Subject: app3/2016/0069 7 Accrington Road Whalley

Dave Bloomer
Highways Development Control
Lancashire County Council

Site Plan
Scale: 1:500

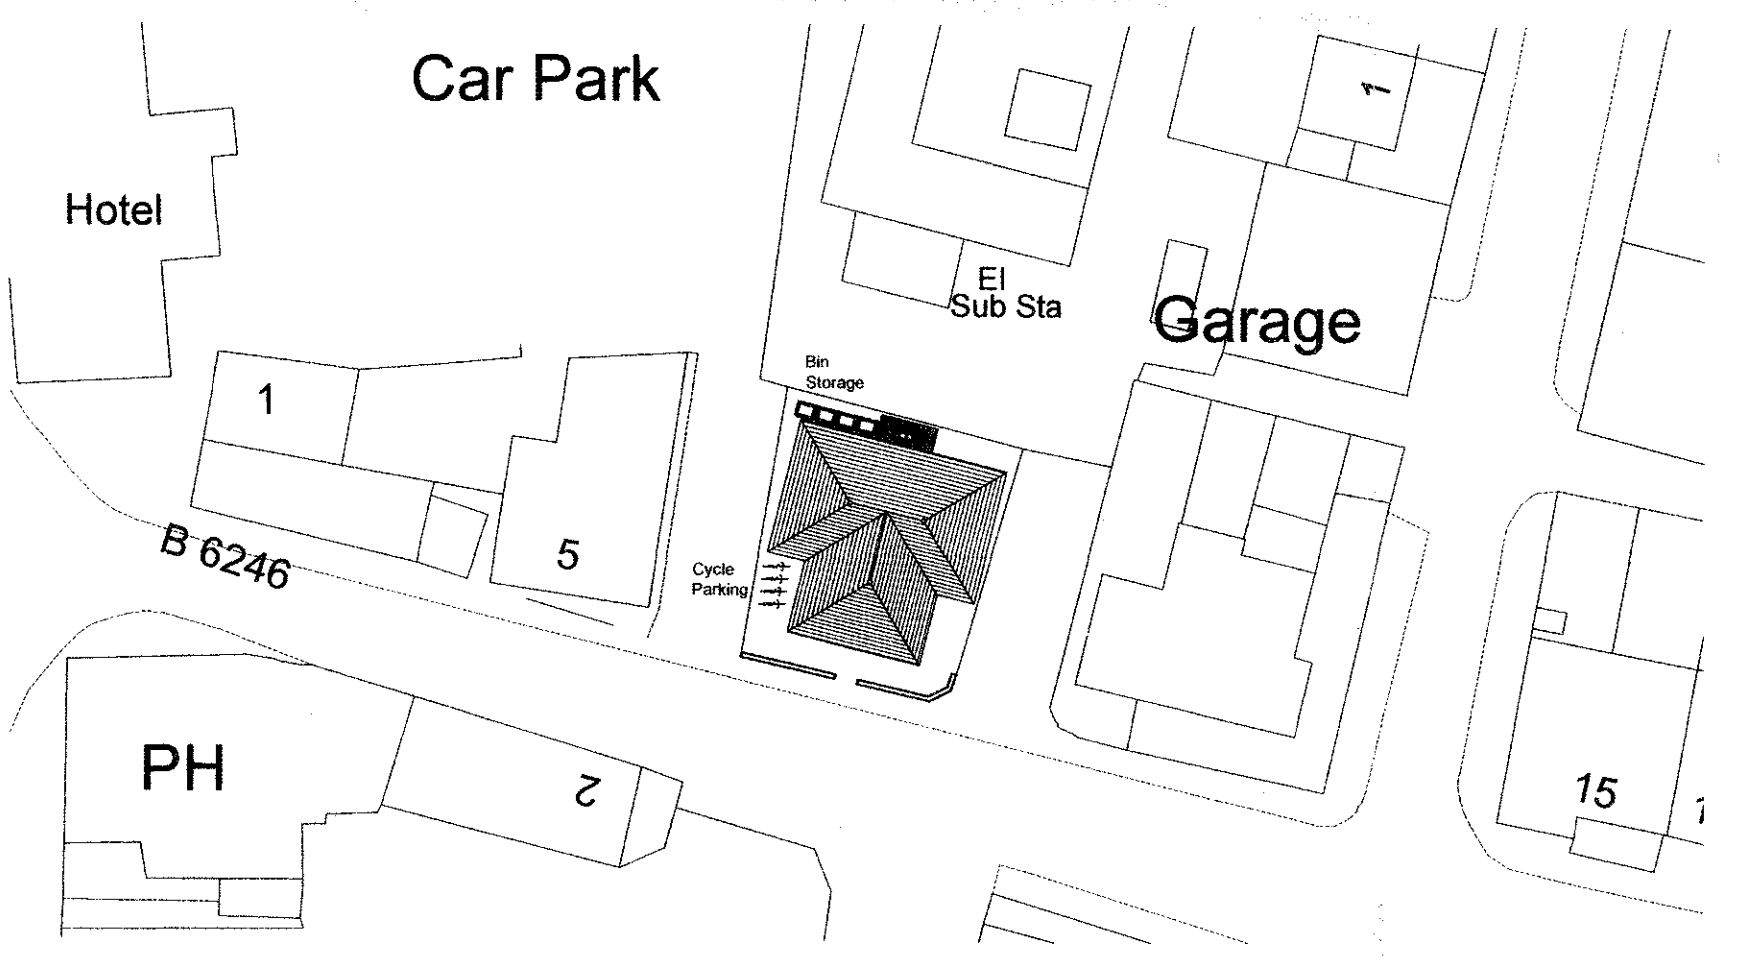
I have previously dealt with the pre-application for this site and whilst raising no objection in principle, I raised a number of concerns relating to the cycle parking provision, the resurfacing of the access road to the substation and access to the bin storage area. Looking at the plans submitted neither of these issues have been attended to.

The conditions above deal with two of the issues raised at the pre application stage, however the access to the refuse bins remains an outstanding concern

1 The new estate road/access between the site and Accrington Road shall be constructed in accordance with the Lancashire County Council Specification for Construction of Estate Roads to at least base course level before any development takes place with the site. Reason: To ensure that satisfactory access is provided to the site before the development hereby permitted becomes operative

2 The cycling facilities to be provided in accordance with a scheme to be approved by the Local Planning Authority and the cycling facilities to be provided in accordance with the approved plan, before the use of the premises hereby permitted becomes operative. Reason: To allow for the effective use of the parking areas.
